Your Ref: 2026/91763

Our Ref: B/02373

25th August 2026

Land off Barnsley Road, Denby Dale, Huddersfield – (KIRK) Erection of 40 residential dwellings and associated works

Dwg No.	Scale	Date	Chg	Rev
E25/8361/001_01B	1/500 @A1	OCT'2025	MH	JM

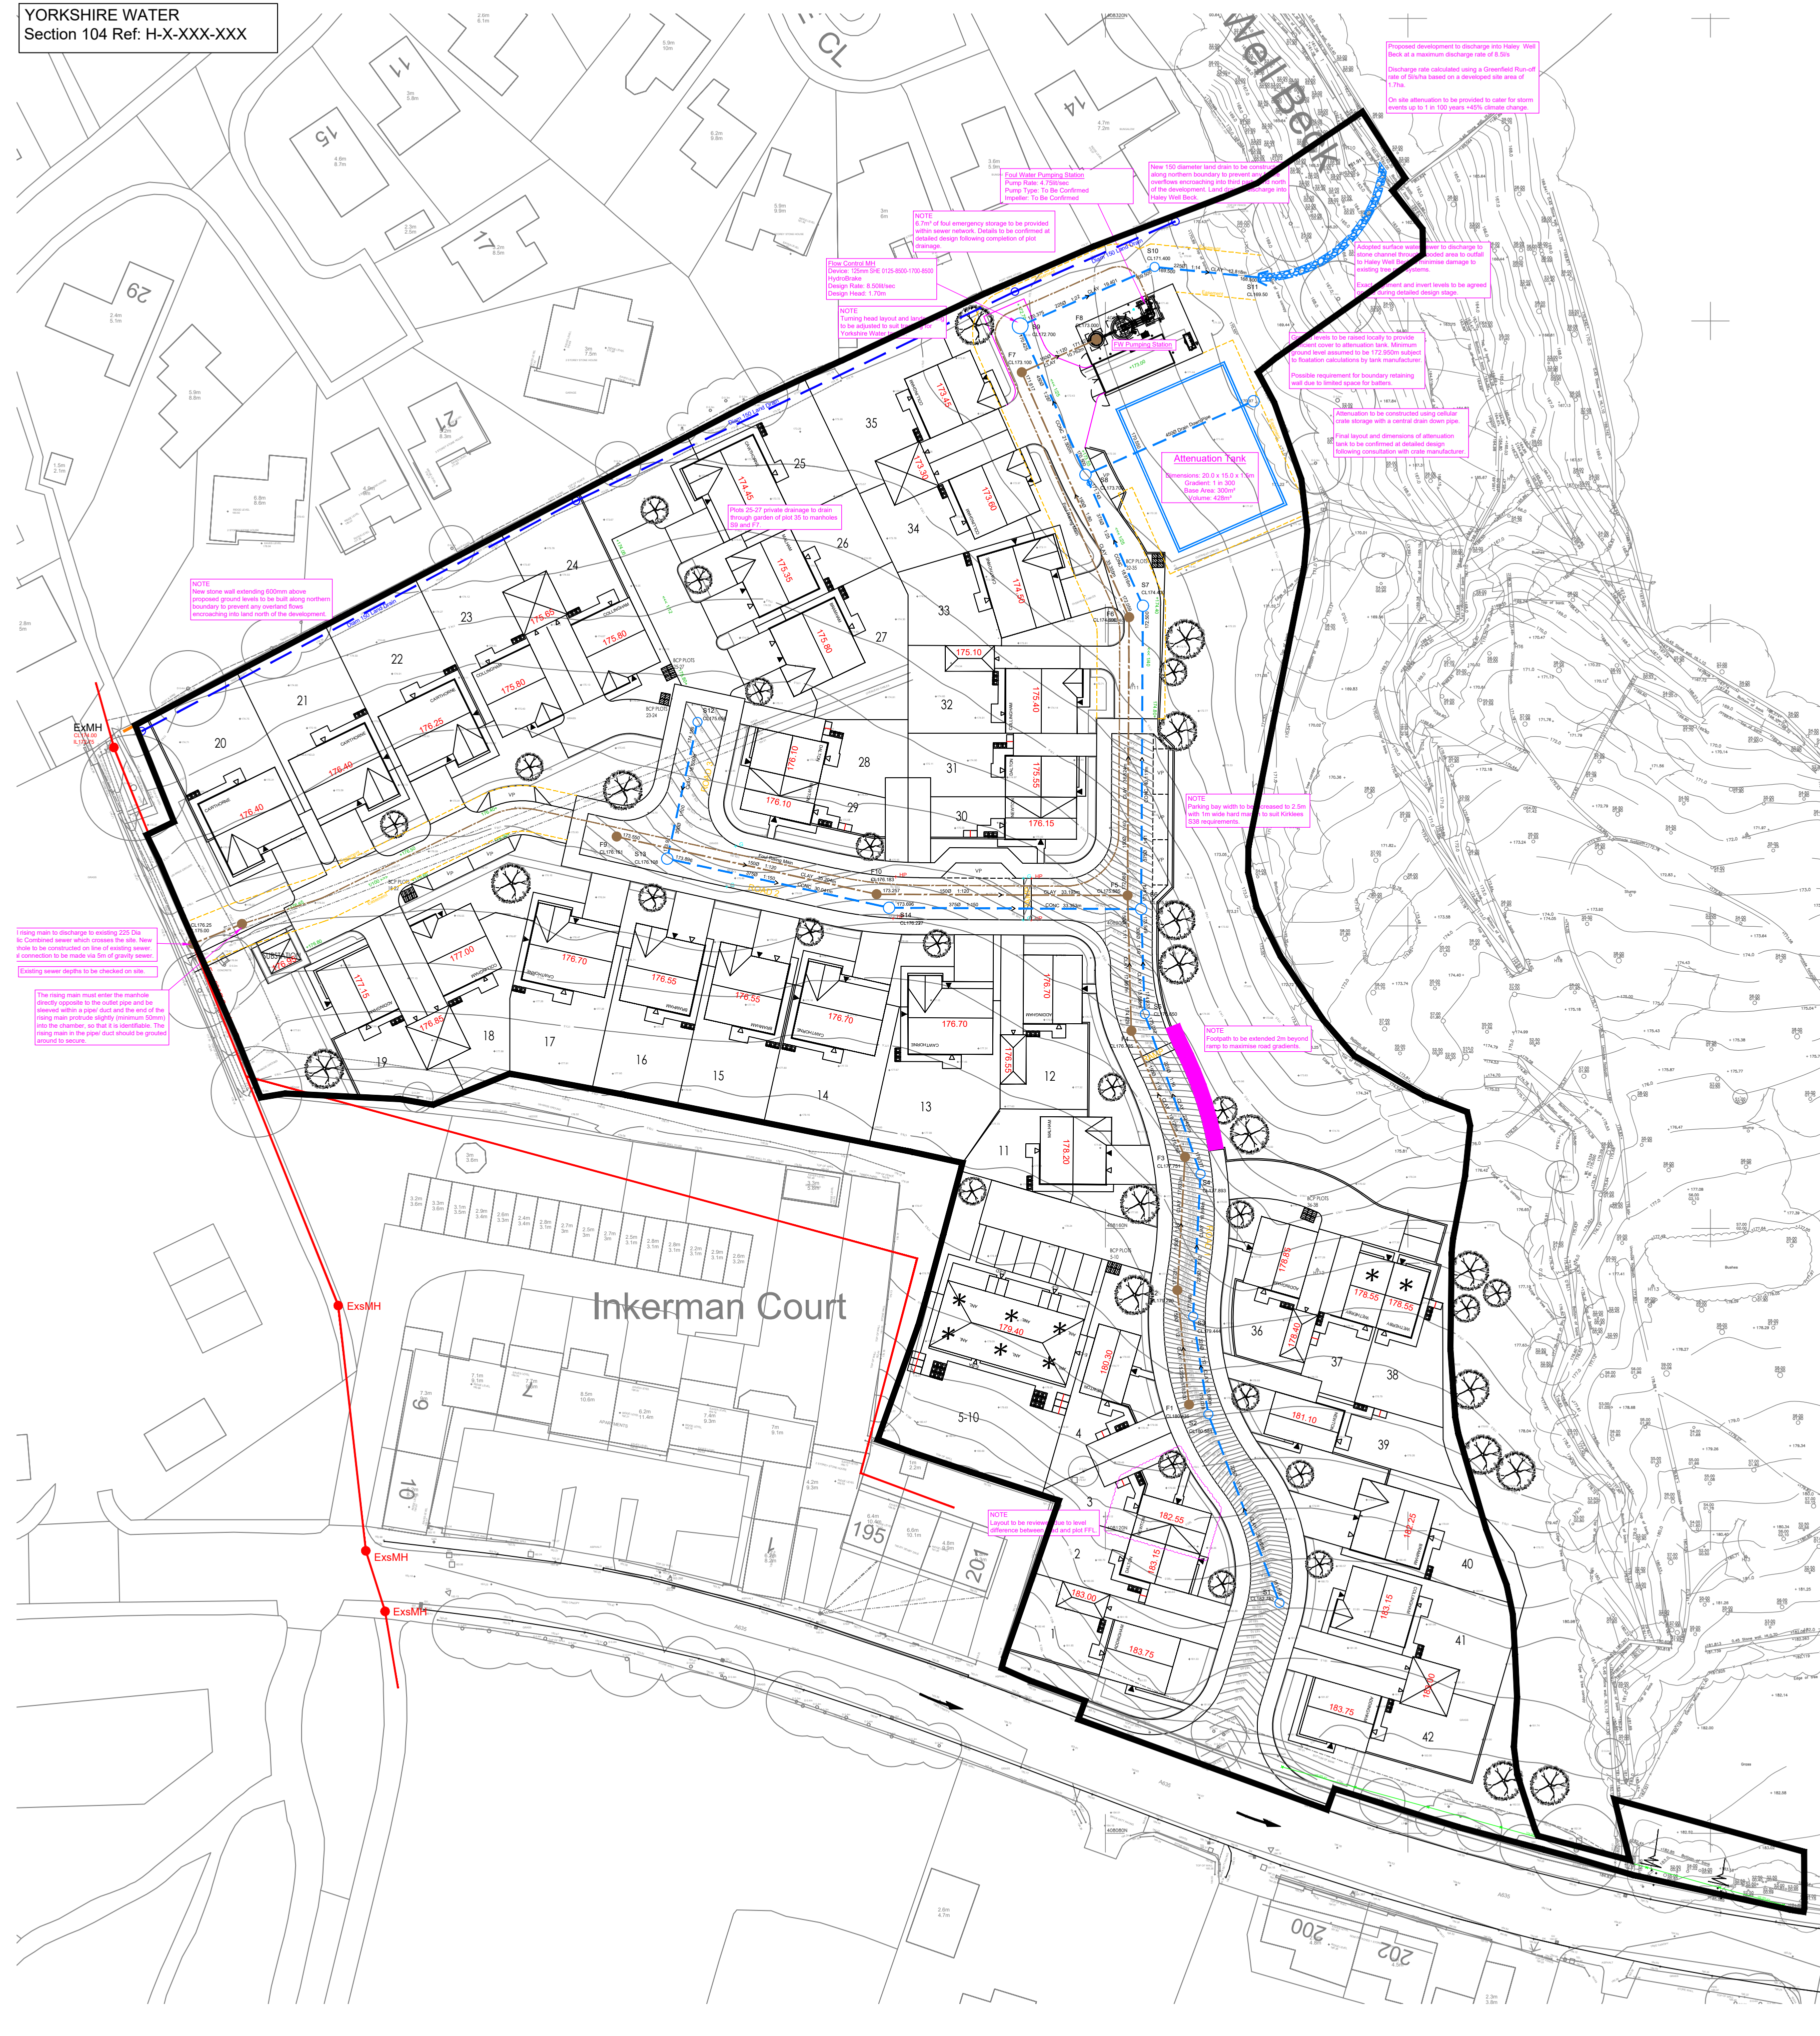
- 1) The proposed separate systems of drainage on site and off site
- 2) The proposed amount of domestic foul water to be discharged to the public combined sewer (pumped at a rate of 4.75 litres/second)
- 3) The proposed point of discharge of foul water to the public 225mm diameter combined sewer west of the site
- 4) The submitted drawing shows surface water proposed to be drained to watercourse

submitted on drawing E25/8361/001_01D (revision D) dated 27/07/2026 that has been prepared by Haigh Huddleston & Associates.

It is noted from the submitted planning application that surface water is proposed to be drained to watercourse.

The developer should note that further restrictions on surface water disposal from the site may be imposed by other parties. The developer is strongly advised to seek advice/comments from the Environment Agency/Land Drainage Authority/Internal Drainage Board with regard to surface water disposal from the site. The landowners consent will be required for the construction of a new outfall structure.
